# BUILDING PERMIT

Located At 163 MAINE AVE

Job ID: 2012-10-5215-DEMO

has permission to Demolition of the existing garage & rebuild a 20' x 24' garage (Single Family Residence), provided that the person or persons, firm or corporation accepting this permit shall comply with all of the provisions of the Statues of Maine and of the Ordinances of the City of Portland regulating the construction, maintenance and use of the buildings and structures, and of the application on file in the department.

163 MAINE AVE - GARAGE RECONSTRUCTION

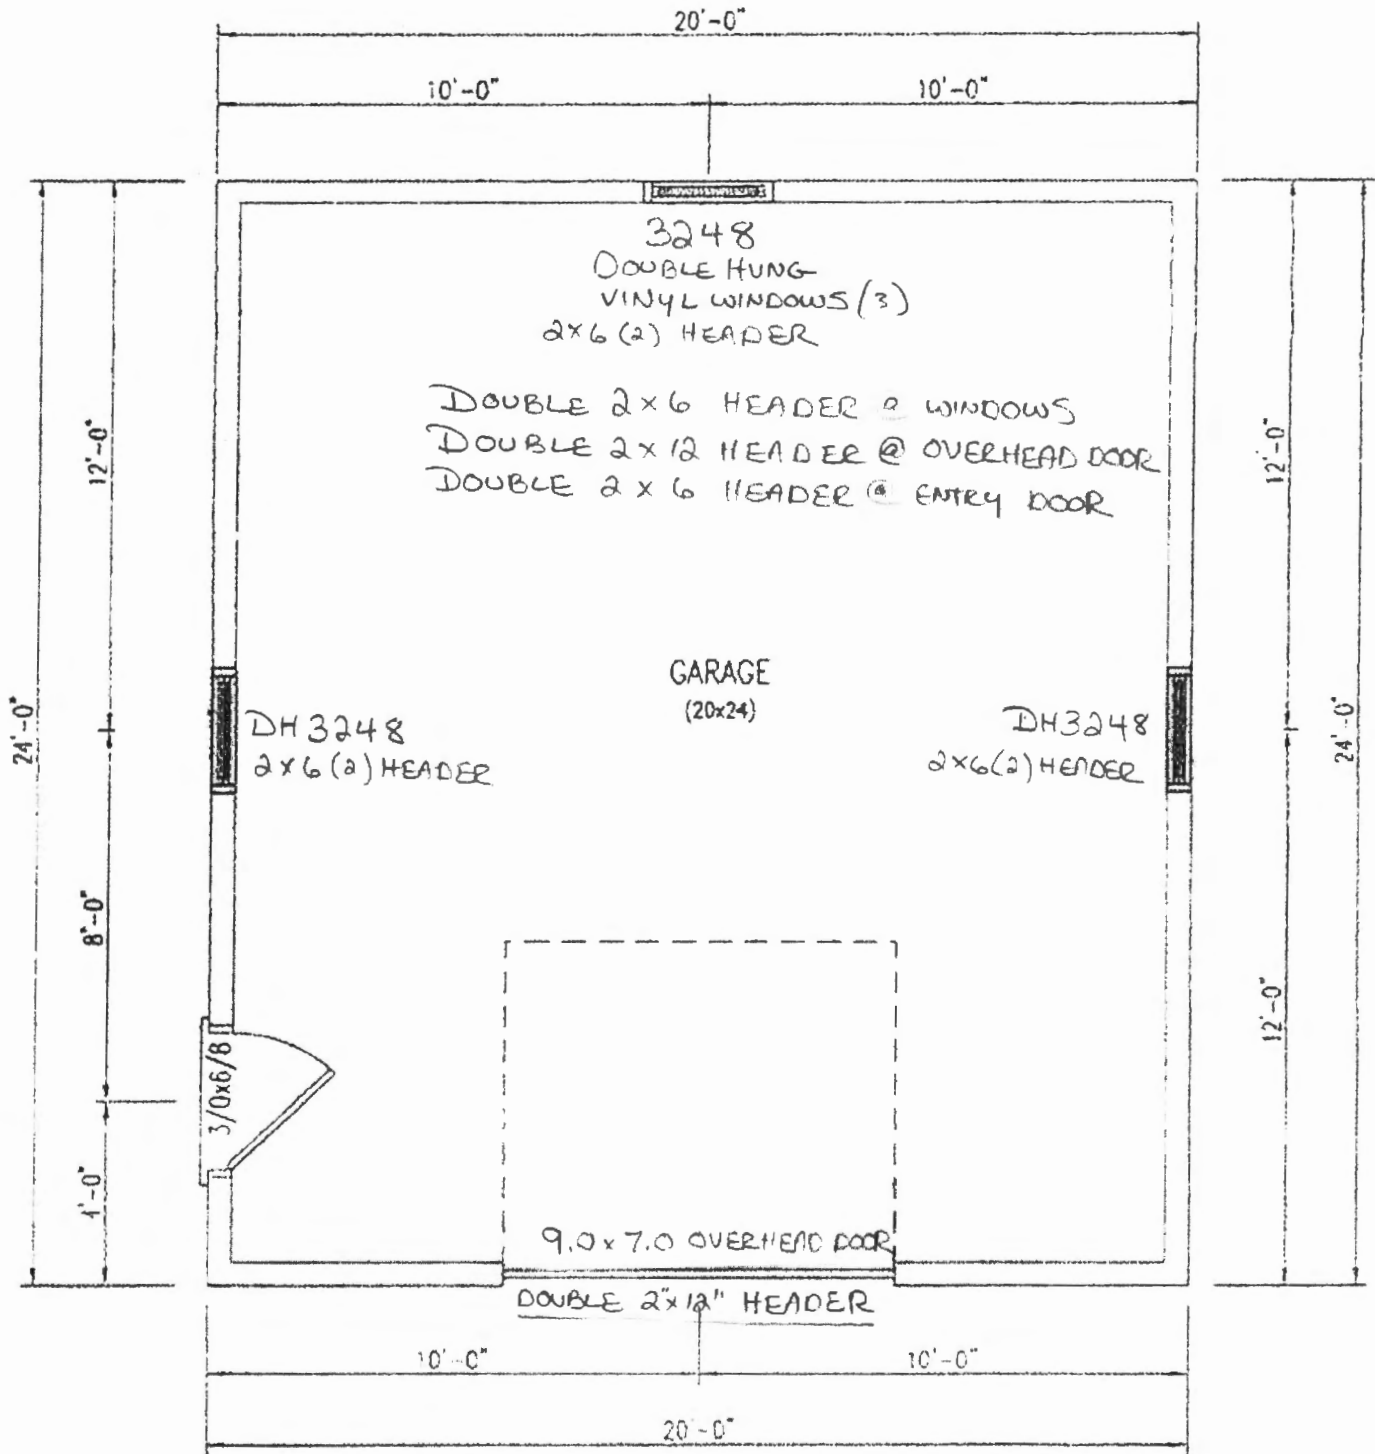
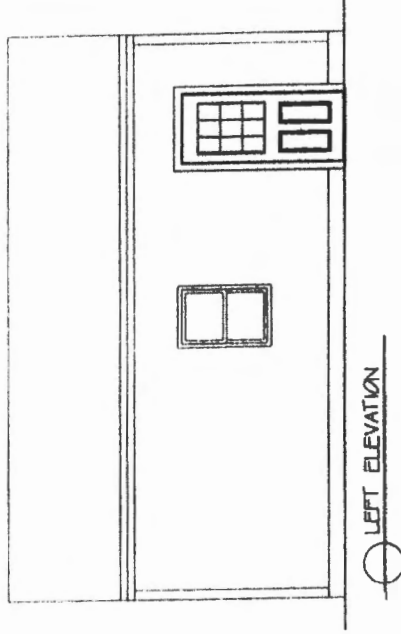
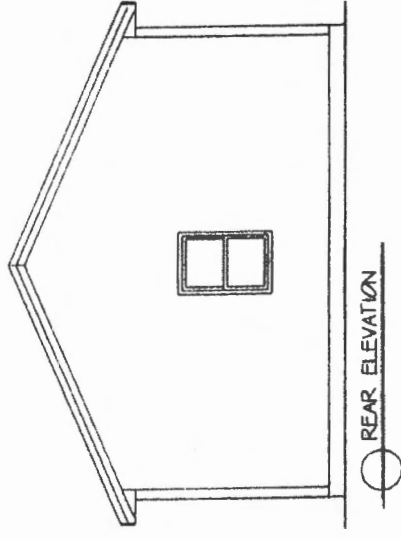
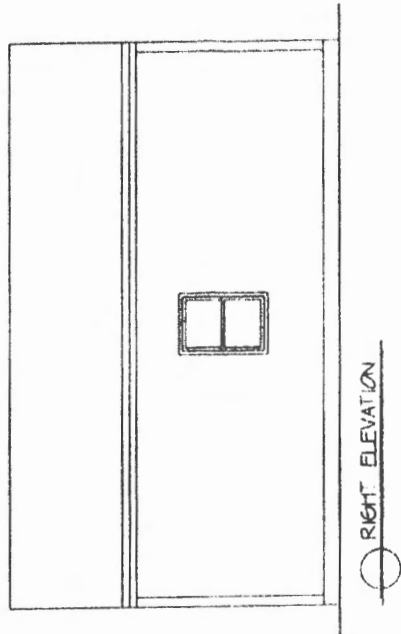
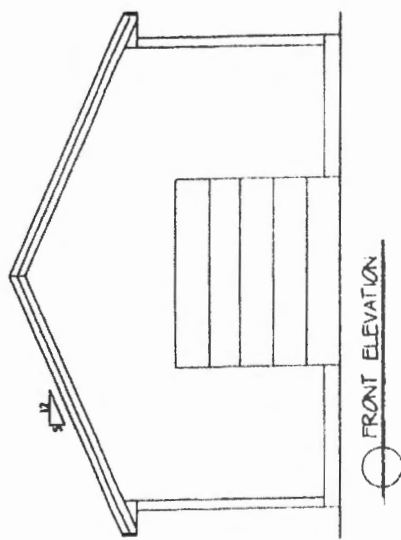
4. See table below for 1 hour fire-resistance rating requirements for the proposed garage wall- three feet from the property line.
